Rezoning Petition Review

Date of Review: February 24, 2020

Rezoning Petition #: 20-25

Location of Property: Approximately 25.97 acres located along the eastern side of Milhaven Ln, south of Sunset Rd and west of Statesville Rd.

SHEET NUMBER  
**RZ-1**

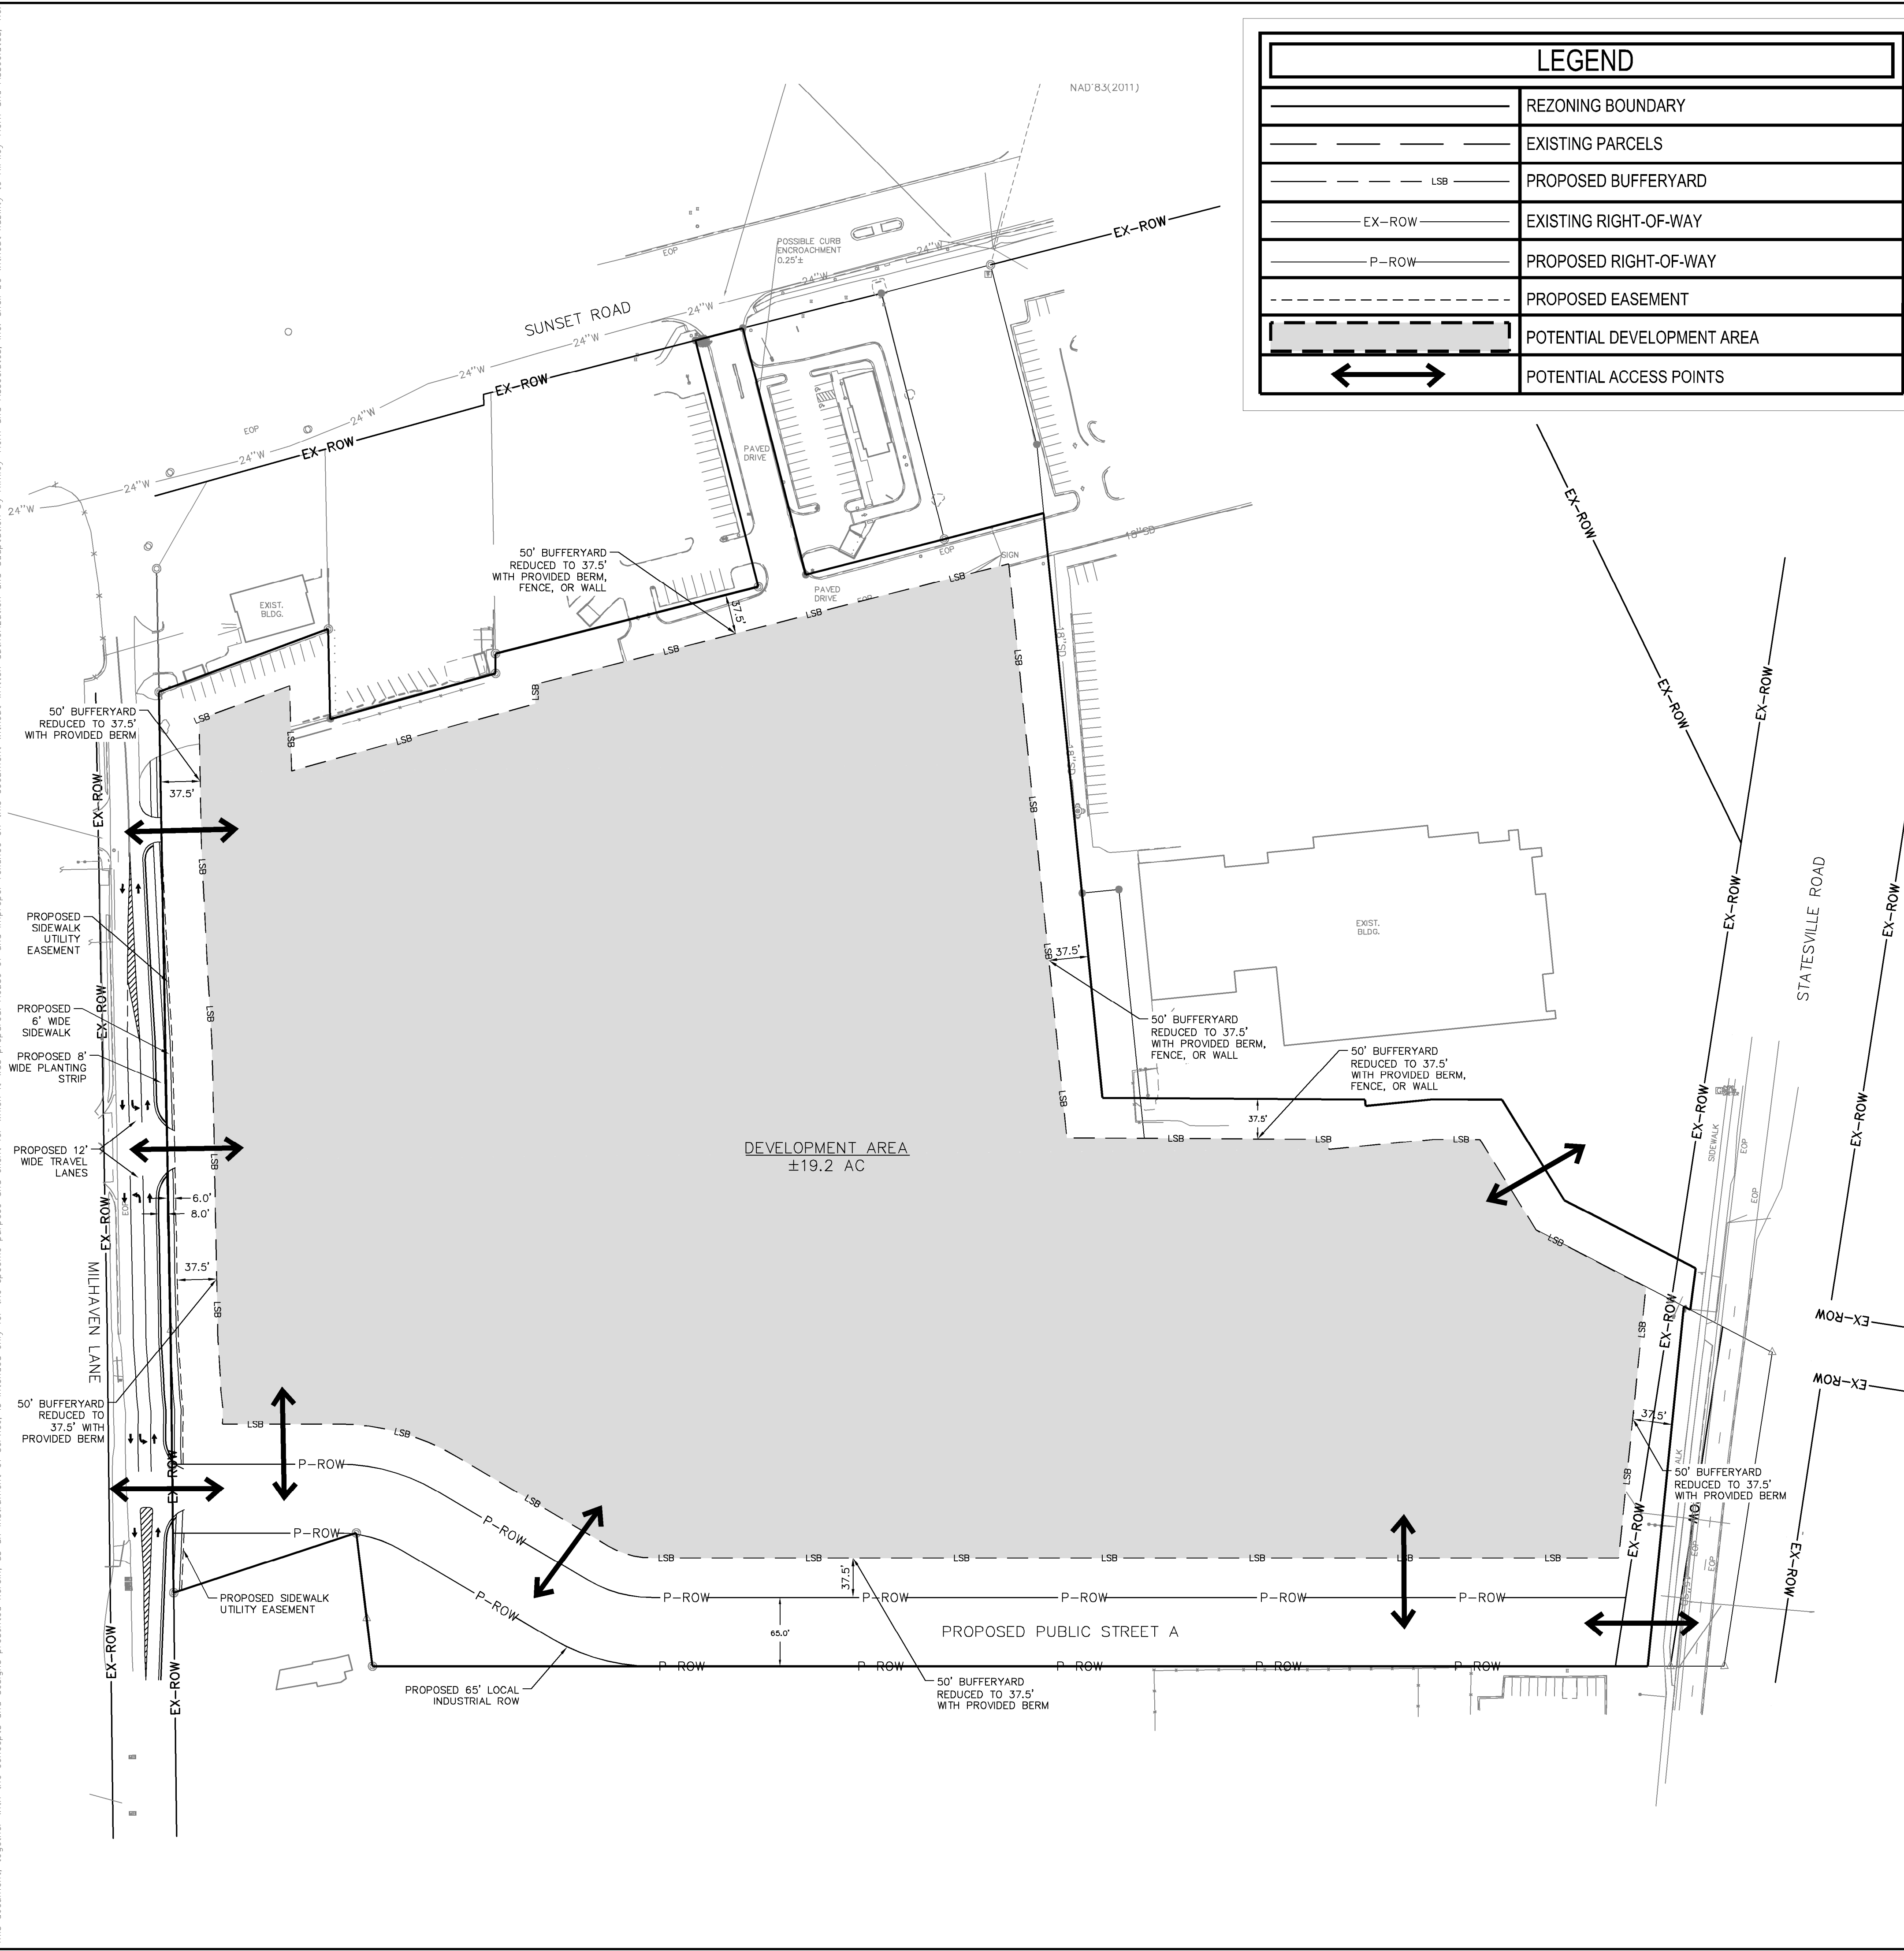
Recommendations Concerning Storm Water: City of Charlotte GIS data indicates a 30-ft PCSO buffer across the site. Please show and label *Potential 30-ft PCSO Buffer* on the site plan. Any increase of impervious area within such buffers may not be allowed and is not approved with the rezoning process. Stream Delineation Reports are subject to review and approval by Charlotte Storm Water Services. Please include the following note under Environmental Features: *"Development within any SWIM/PCSO Buffer shall be coordinated with and subject to approval by Charlotte-Mecklenburg Storm Water Services and mitigated if required by City ordinance."*
